Our Ref: BE/127/12/A
Your Ref:

Town & Country Planning (Control of Advertisement) (England) Regulations 2007 (as amended)
Application for Consent to Display an Advertisement(s)

Development Various non-illuminated & internally illuminated signage

Location Former LEC Site Shripney Way Bognor Regis

DRAWING
ADVERTS APPLICATION
DRAWING

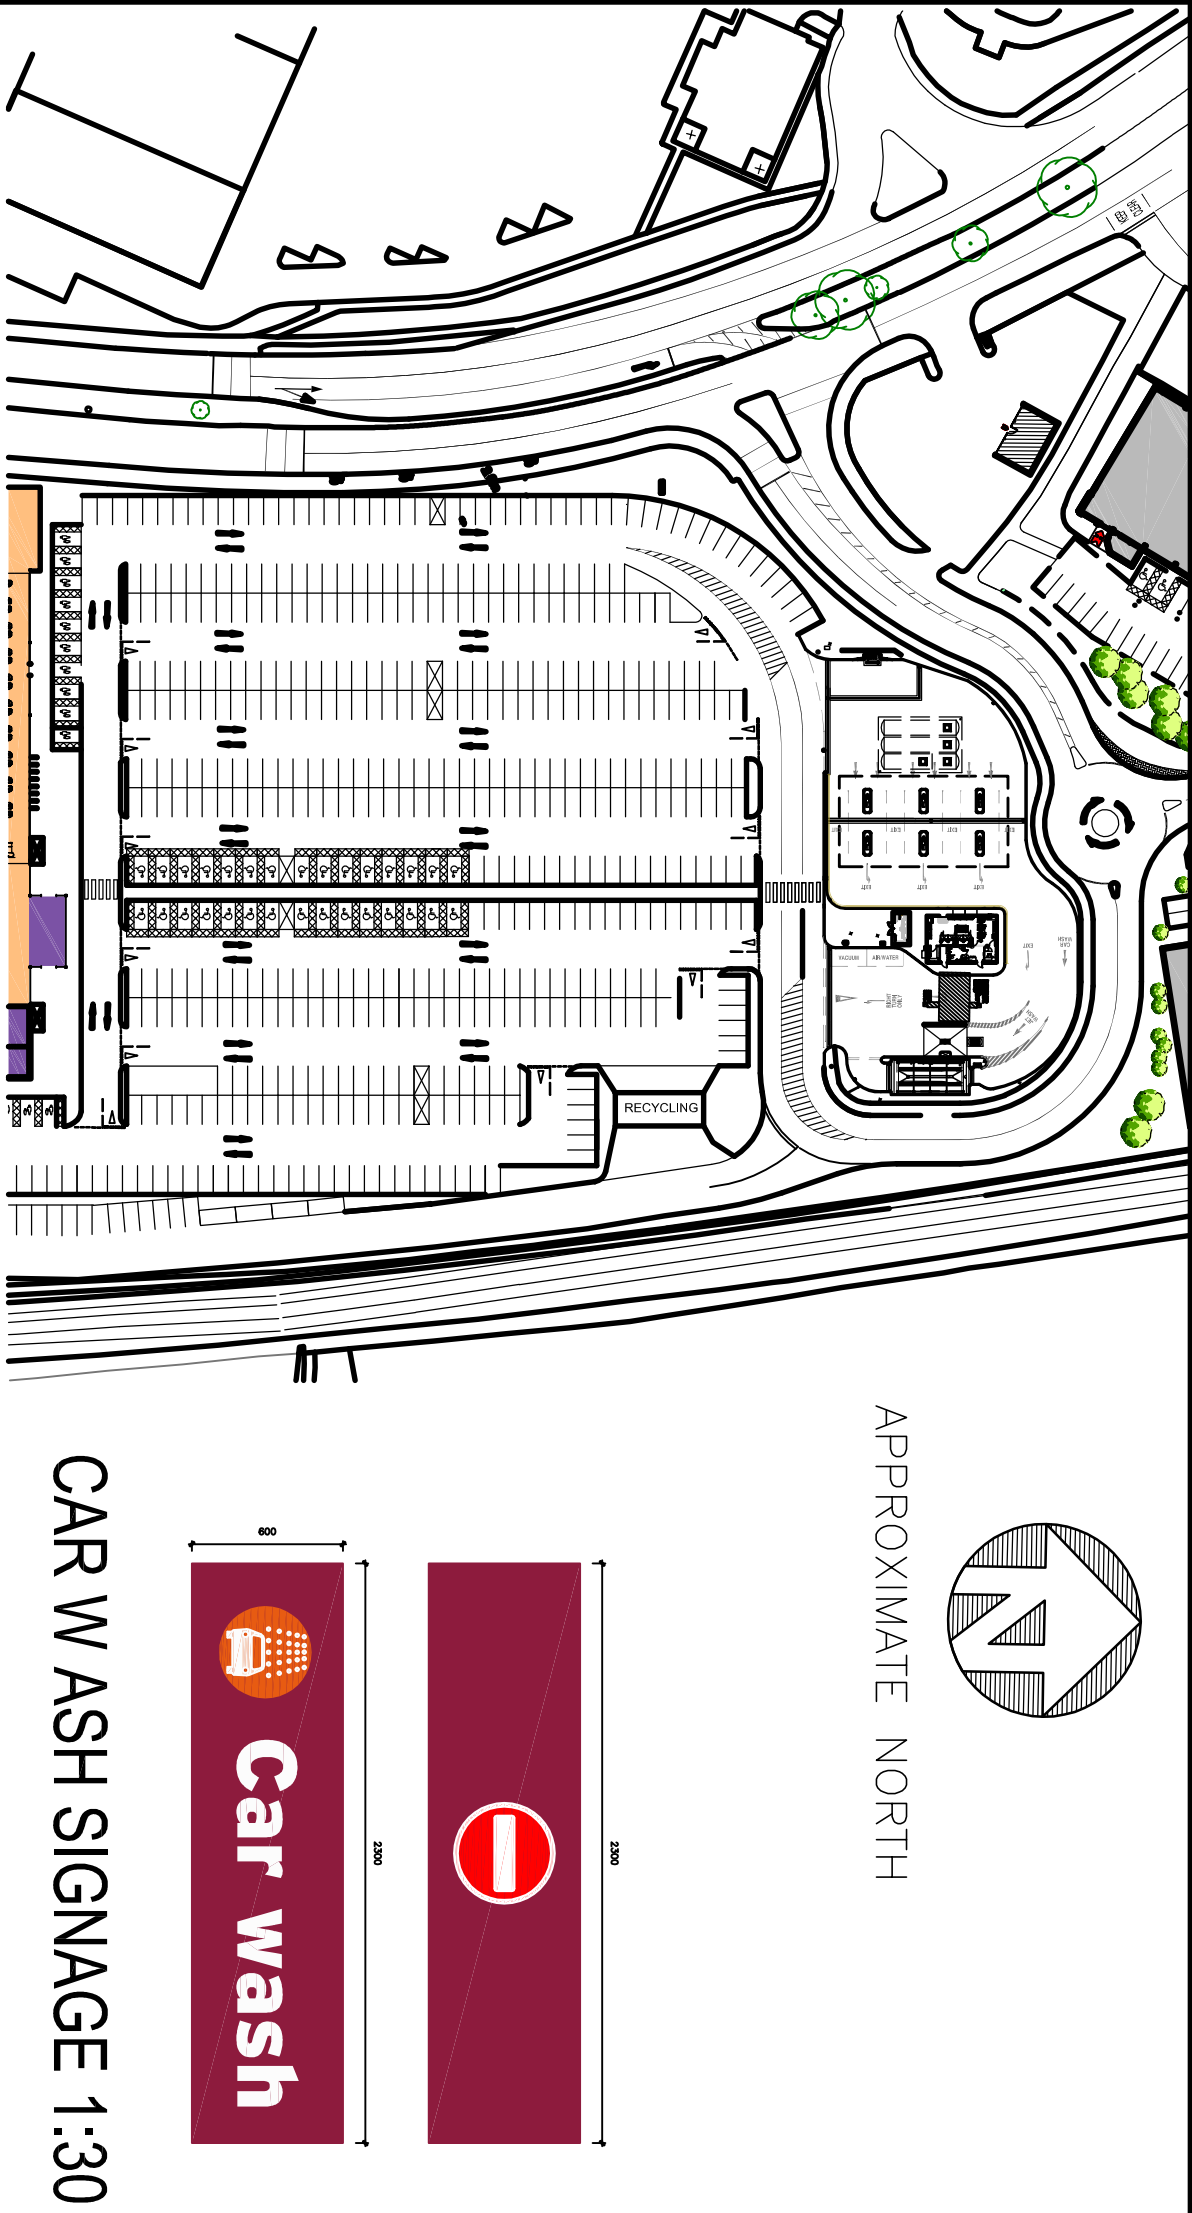
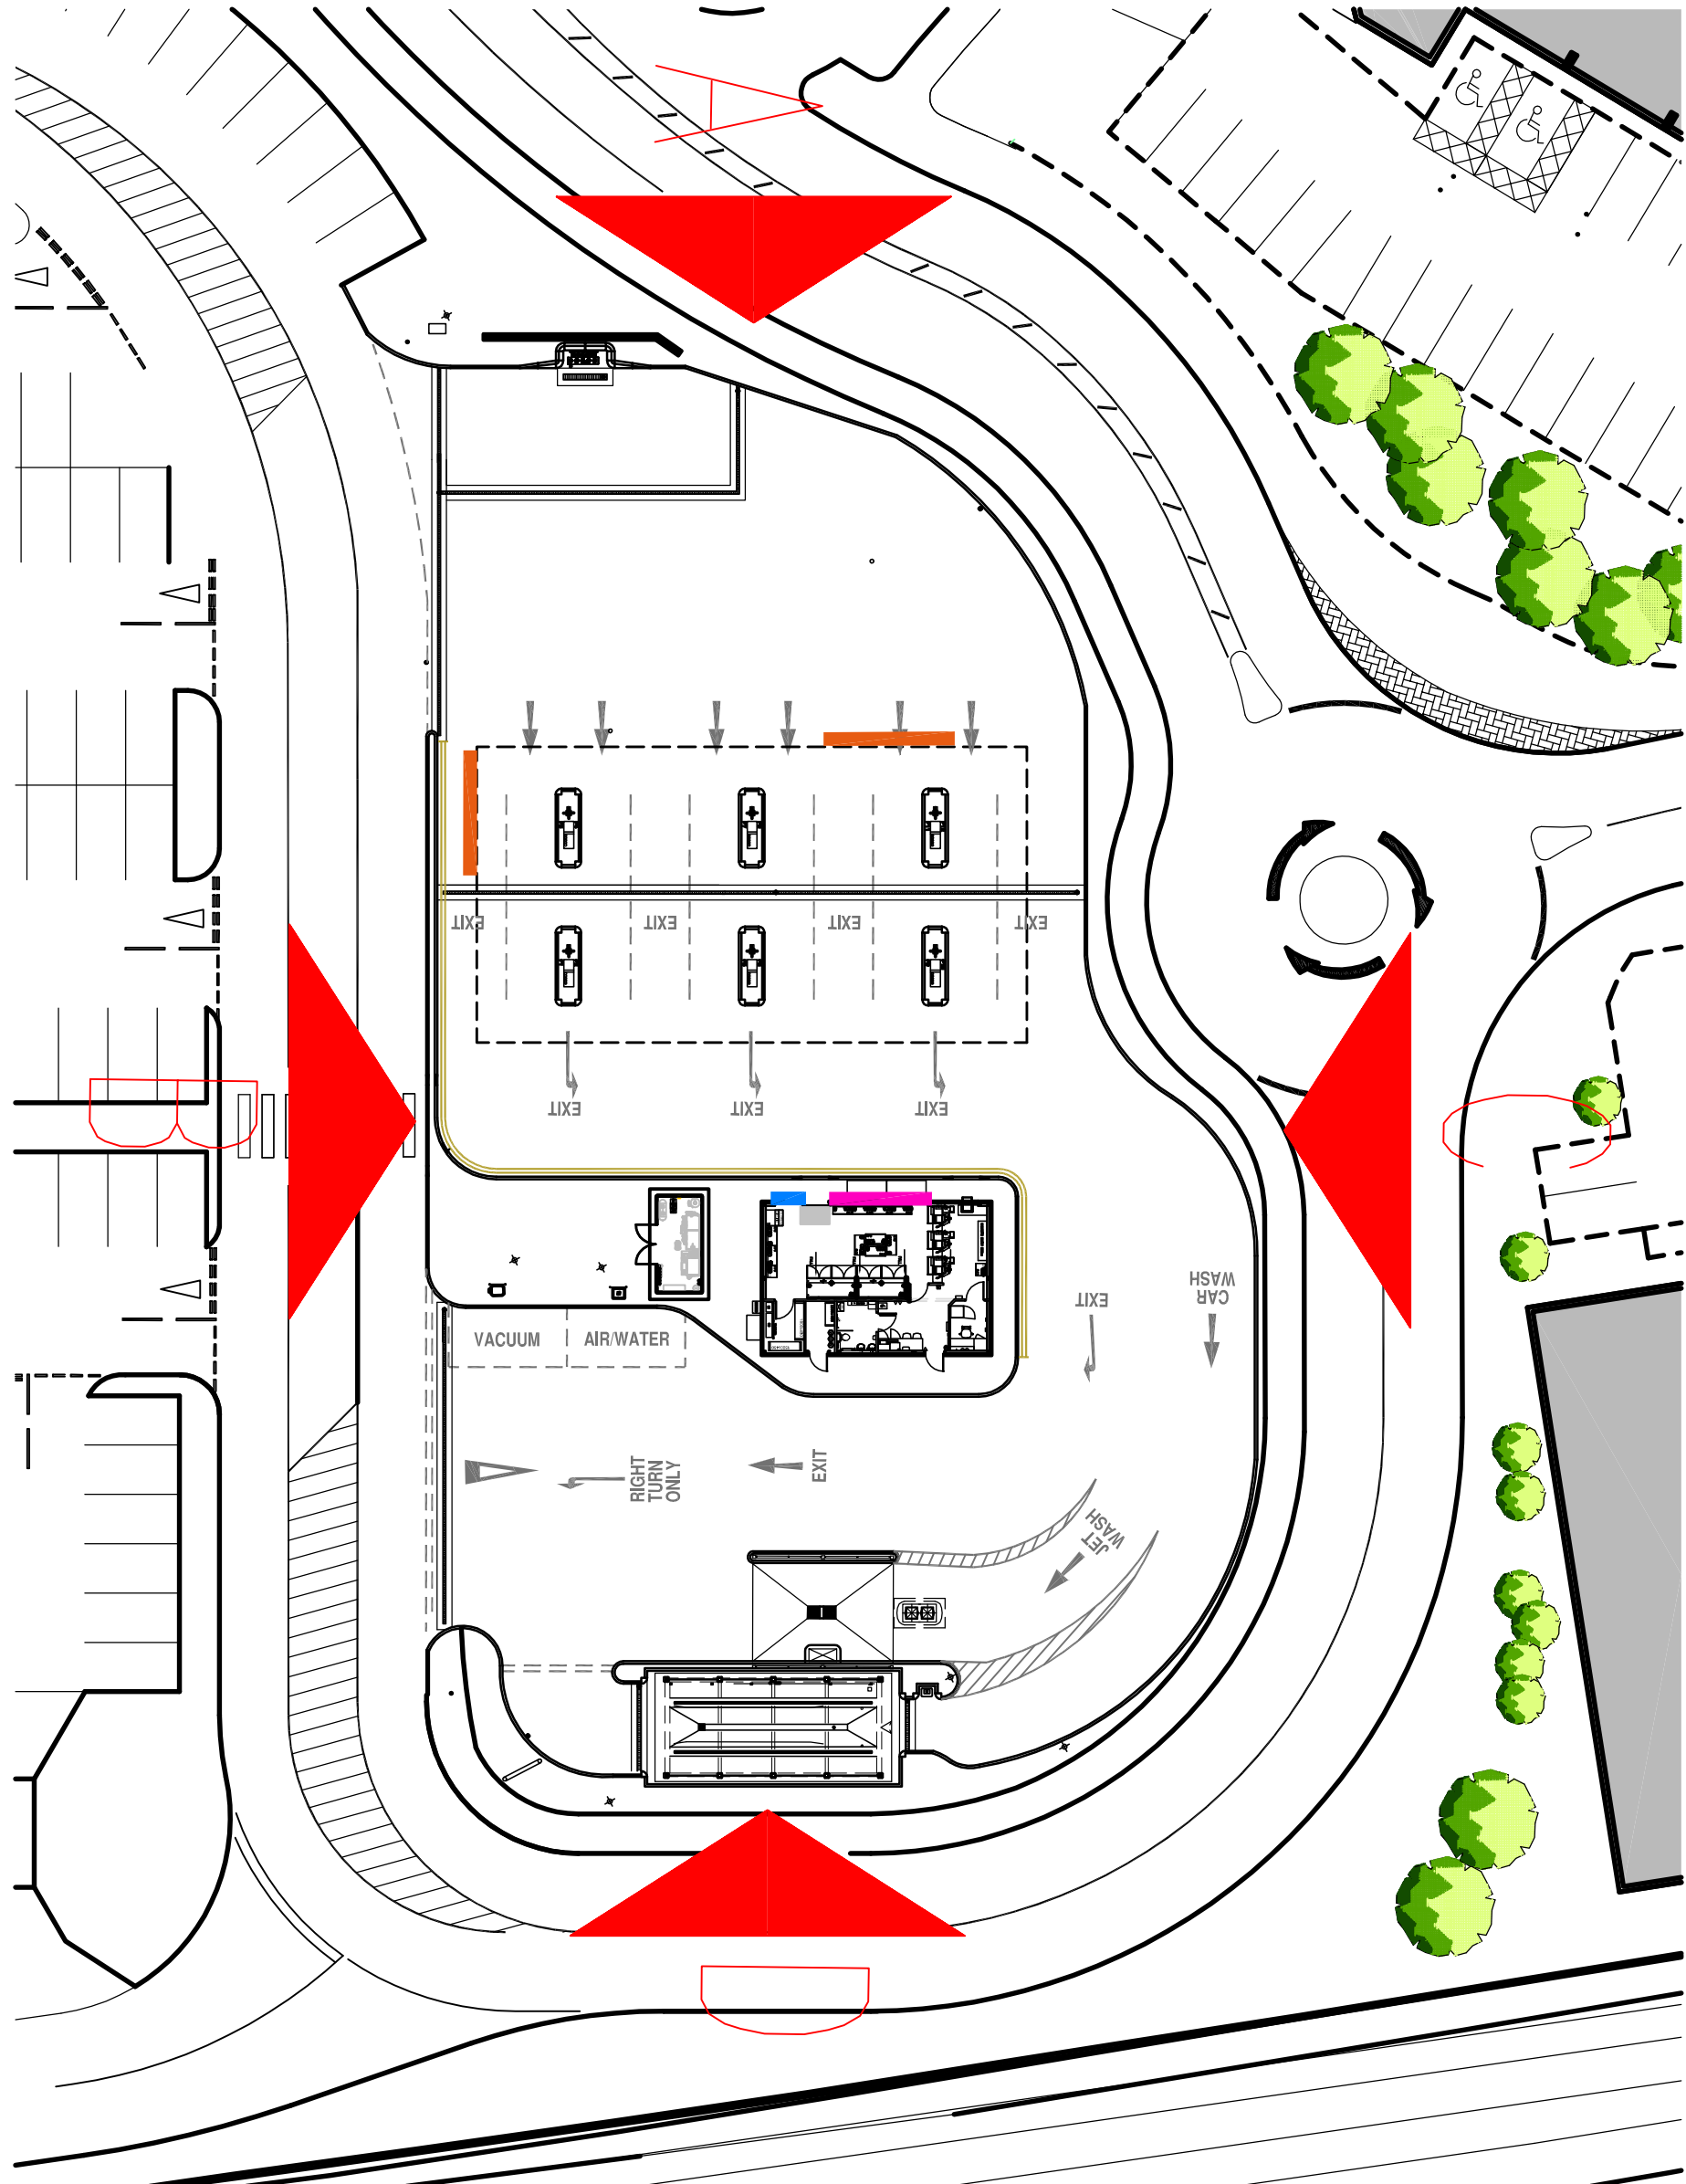
- The building signs (schedule) do not appear to be shown on the plans. Please amend.
- The schedule shows 1 'welcome to Bognor Regis' vinyl and 2 Sainsbury's wall vinyls. However the plans only seem to show 2 'welcome to Bognor Regis' vinyls and no Sainsbury's wall vinyls. Please amend.
- Other than the PFS totems, none of the petrol filling station signage on plan no. 2486/200 Rev A is shown on the schedule. Please amend.
